**RE: Uptown Shops  
Conceptual Grading & Drainage Plan  
Engineer's Stamp Date: none (File: J19D071A)**

Based upon the information provided in your submittal received 1-5-16, the above referenced plan is approved for action by the DRB on the Site Plan for Building Permit.

CONCEPTUAL
GRADING &
DRAINAGE PLAN

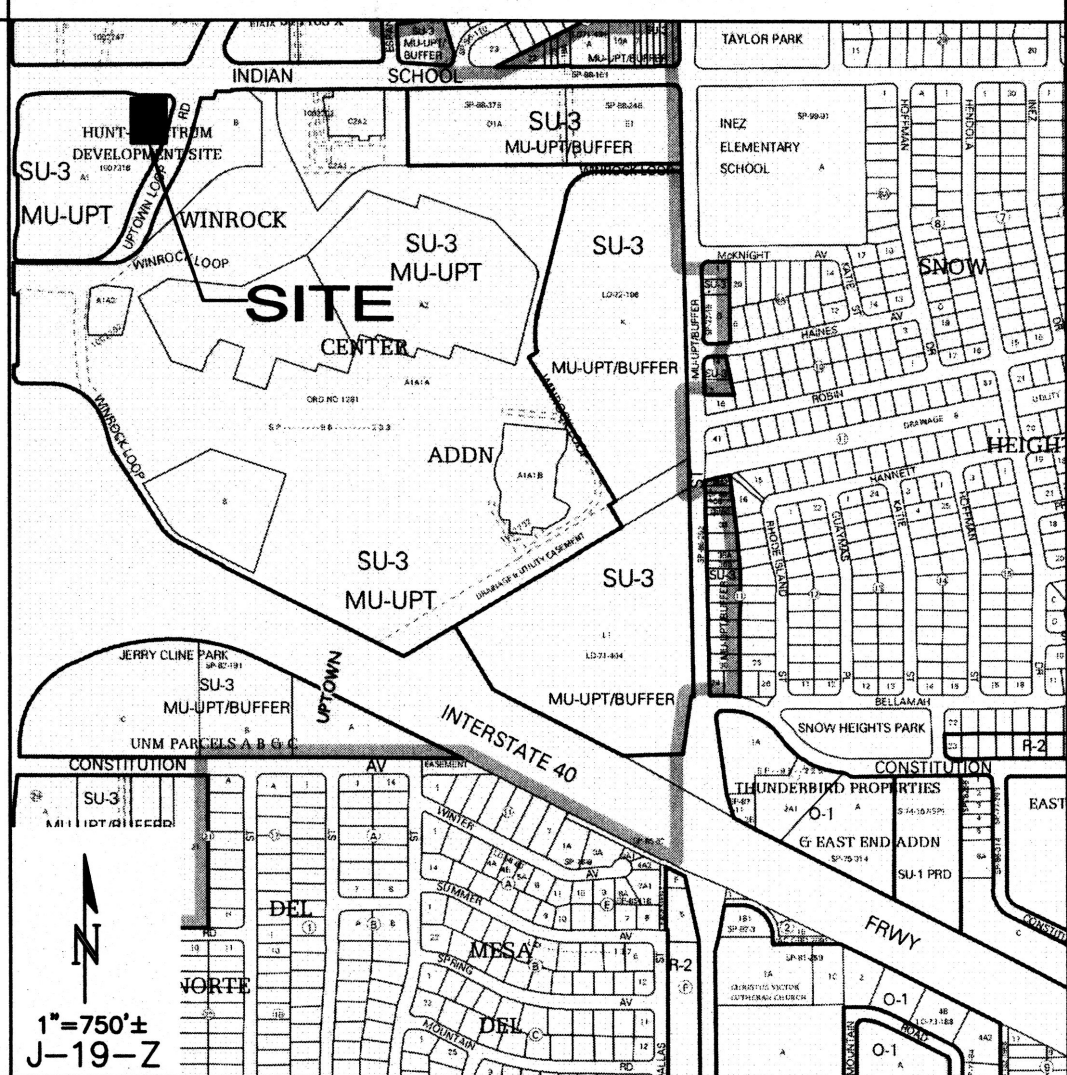
1. The private storm drain to be removed did not show on the plan.
2. Provide First Flush volume calculations.
3. It appears that the patio wall is a retaining wall and should be called out as such.

4. Provide contours and Bottom of Pond elevations for the First Flush ponds on the north side of the proposed building. There does not appear to be sufficient space for much ponding without compromising the subgrade of the sidewalk, or the retaining wall/patio wall footing. Perhaps the east patio can discharge to the pond on the SE corner of the building, with just the west patio discharging to the ponds north of the building.

5. How will the ponds on North side discharge? Via Sidewalk culverts or PVC pipes under SW to Back of Curb? In either case, a "Mini Work Order" will be required. Contact the City Engineer to arrange. The entrance will also need to be on the Mini Work Order.

6. Since this project will not be going thru DRC, show the curb return quarter point elevations.
7. Call out a Valley Gutter at the entrance drivepad.
8. The roof of the western portion of the proposed building should discharge at the SW corner so that as much runoff as possible can be collected by the First Flush pond on west side of entrance drivepad. Will a sidewalk culvert direct the roof flows to the parking lot?
